Historic England

26 April 2021

**BROOKES MILL, ARMITAGE ROAD, ARMITAGE BRIDGE, HUDDERSFIELD, HD4
7NR**

Application Nos 2021/90585 & 2021/90584

Proposed Wellness Centre: Context Section & Elevation

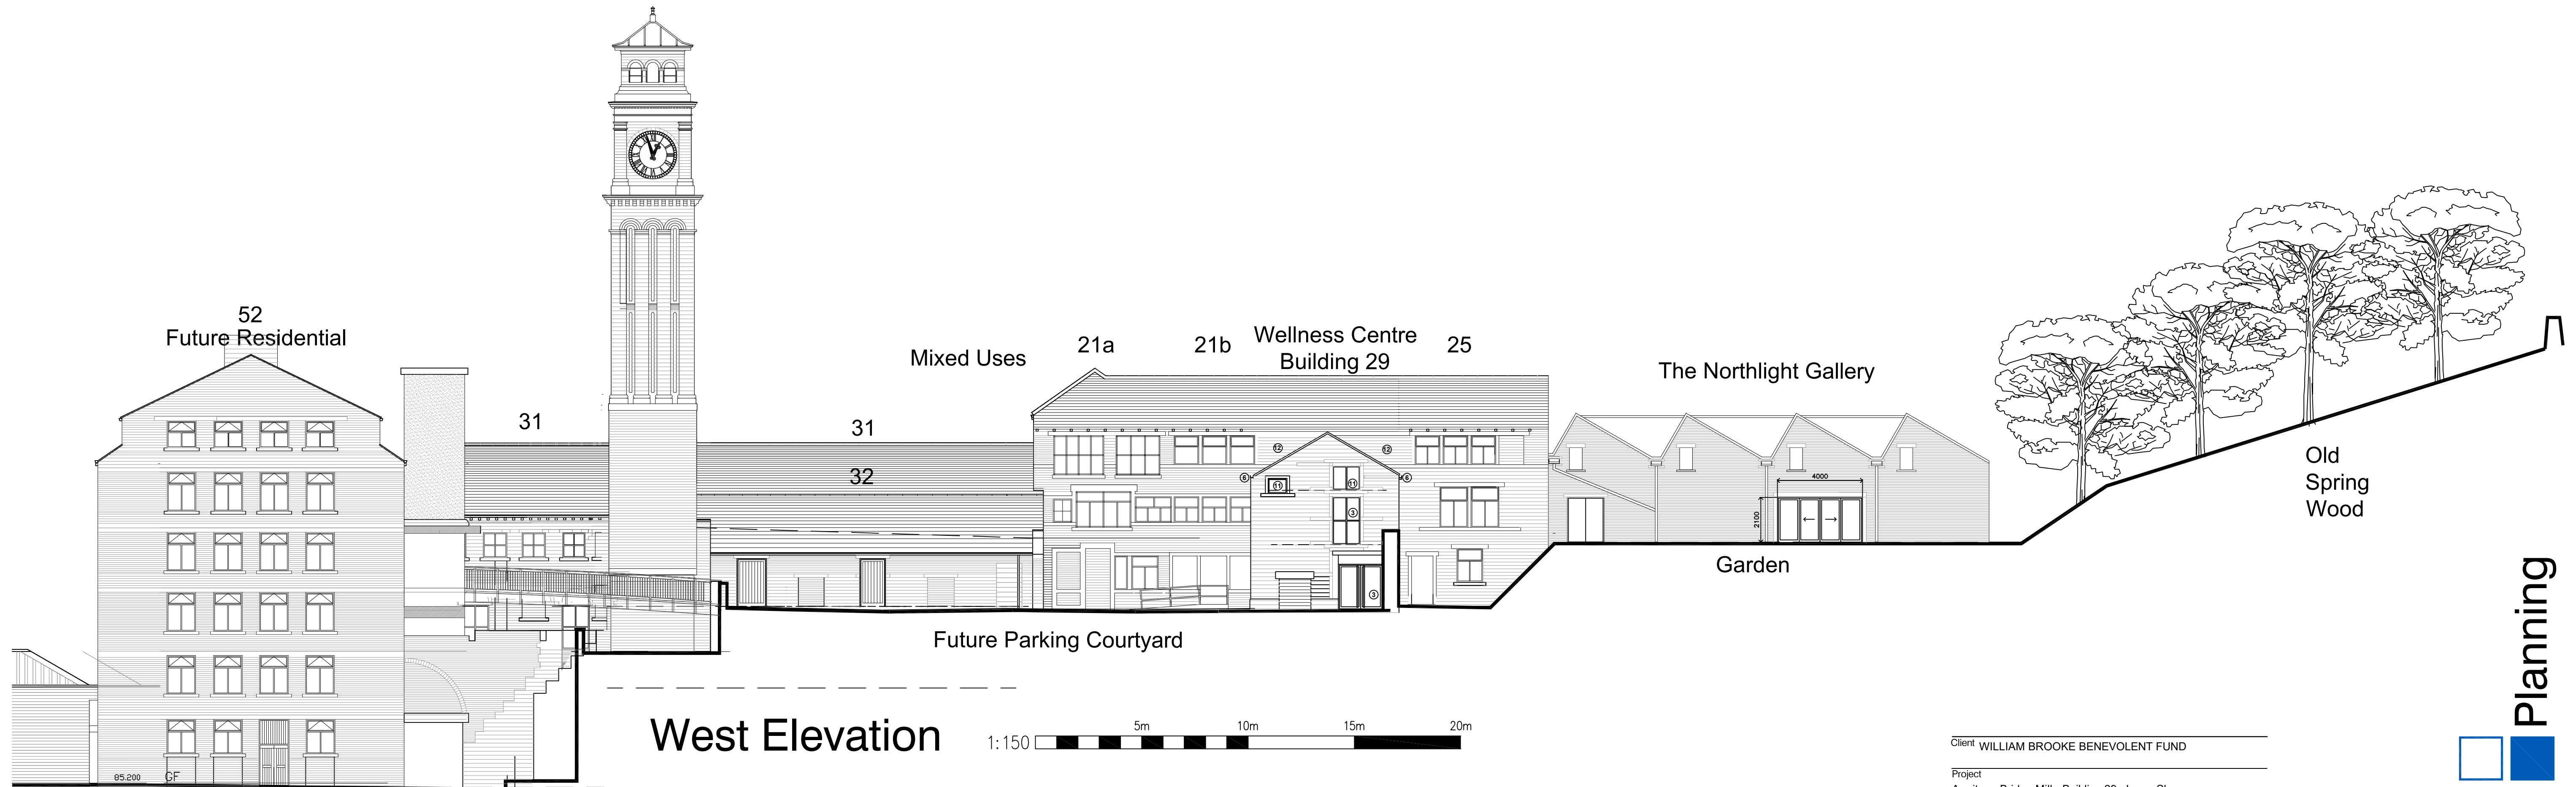
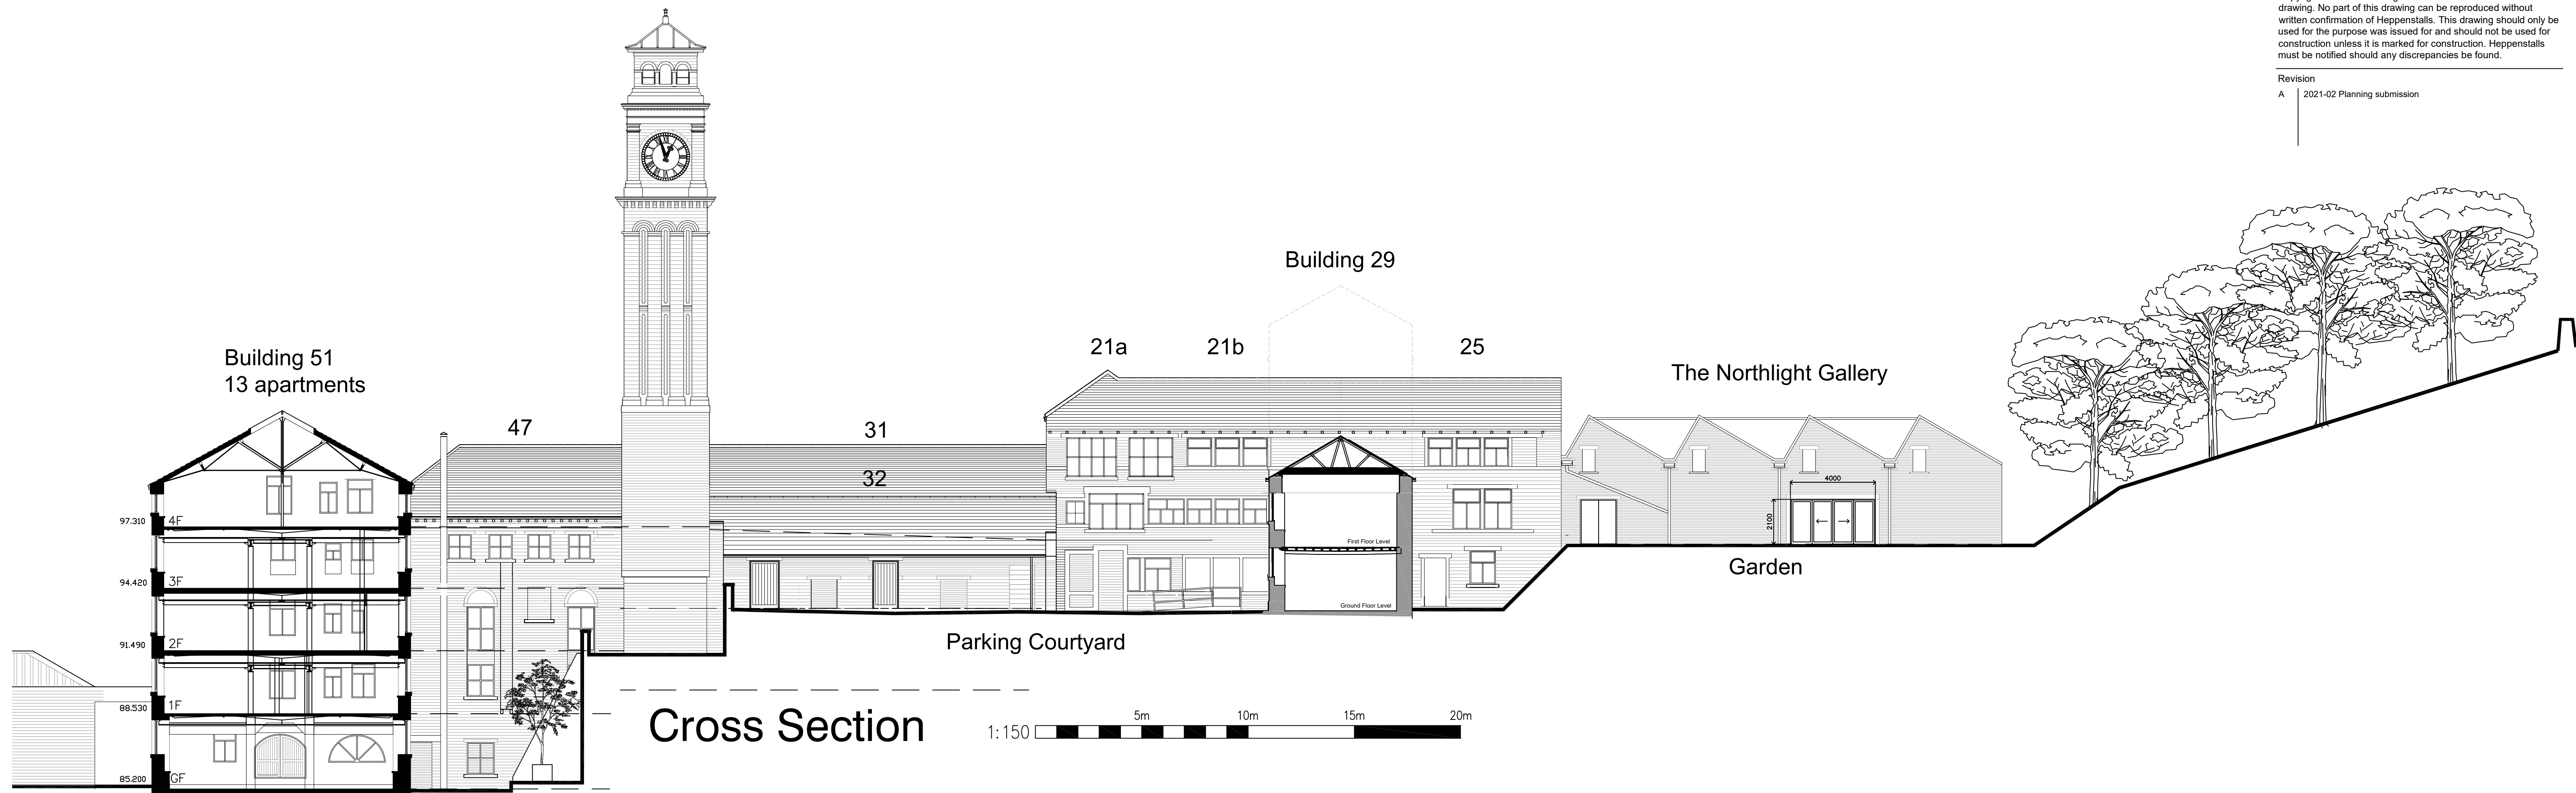
The current proposals seek the demolition of the three upper storeys of Building 29 - the former loom shop - and the conversion of the remaining floors for its use as a wellbeing centre.

The partial demolition of the building will substantially alter one of the earliest buildings within the site, diminishing its prominence. This in turn would affect the historic significance of the whole complex.

The reduction in height of the building would also have a detrimental impact on the setting of the grade II listed tower. We note that the recently created courtyard has the potential to become a new arrival space - appearing as a future car park and piazza courtyard in the submitted plans - and therefore the prominence of this view becomes even more critical. The proposed reduction in height would detract from this powerful image conveyed by the tower framed by the tall buildings on either end.

We acknowledge the challenges of finding new viable uses to this extensive complex and admit that considerable change may need to be accepted to ensure the long sustainability of the site. However, as one of the earliest buildings and a prominent building within the mill complex, the scale and form of Building 29 should be retained.
